PRE-HEARING STAFF ANALYSIS

Rezoning Petition No. 2008 -051

Request: CC S.P.A., commercial center site plan amendment

SITE PLAN

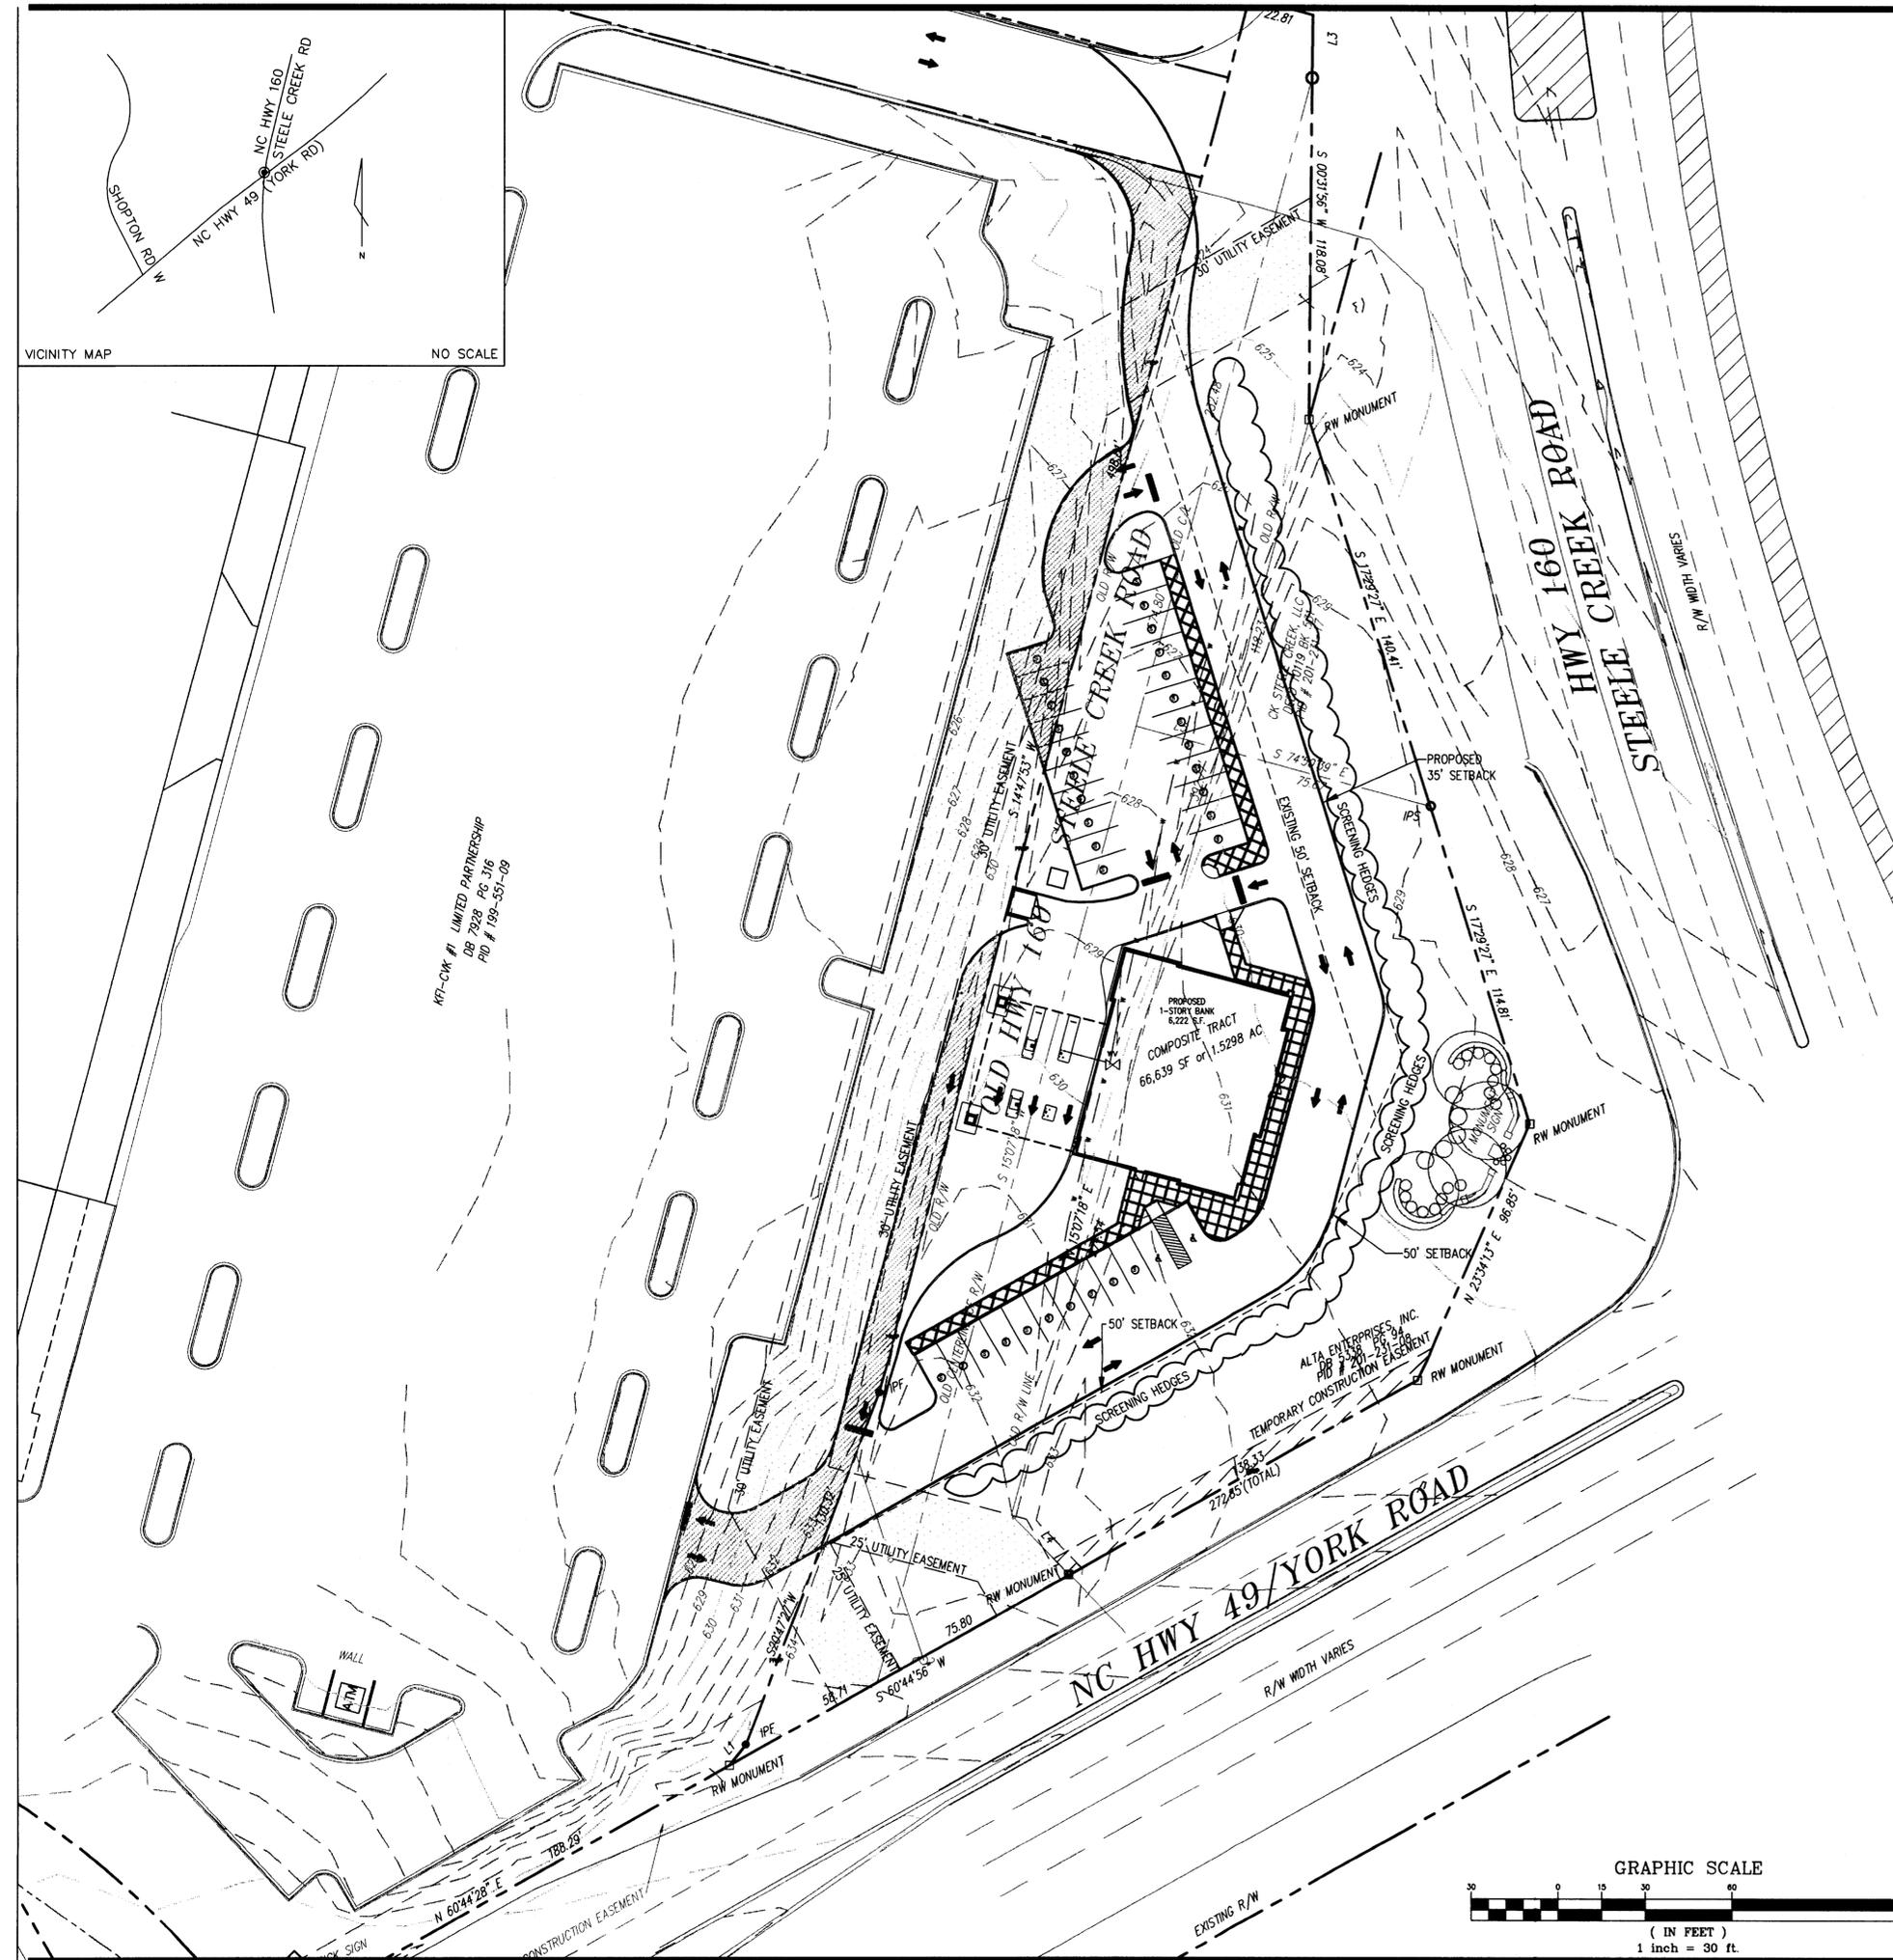
Site plan. The following site plan issues are outstanding:

- The petitioner should add a note to the site plan that all lighting will be full cut off fixtures.
- The site plan should show dumpster location and screening.
- The petitioner should add a note on the site plan that a 8' foot planting strip and 5' foot sidewalk be constructed along Steele Creek Road and York Road.
- The petitioner needs to remove the construction drawing of the revised site plan submittal.
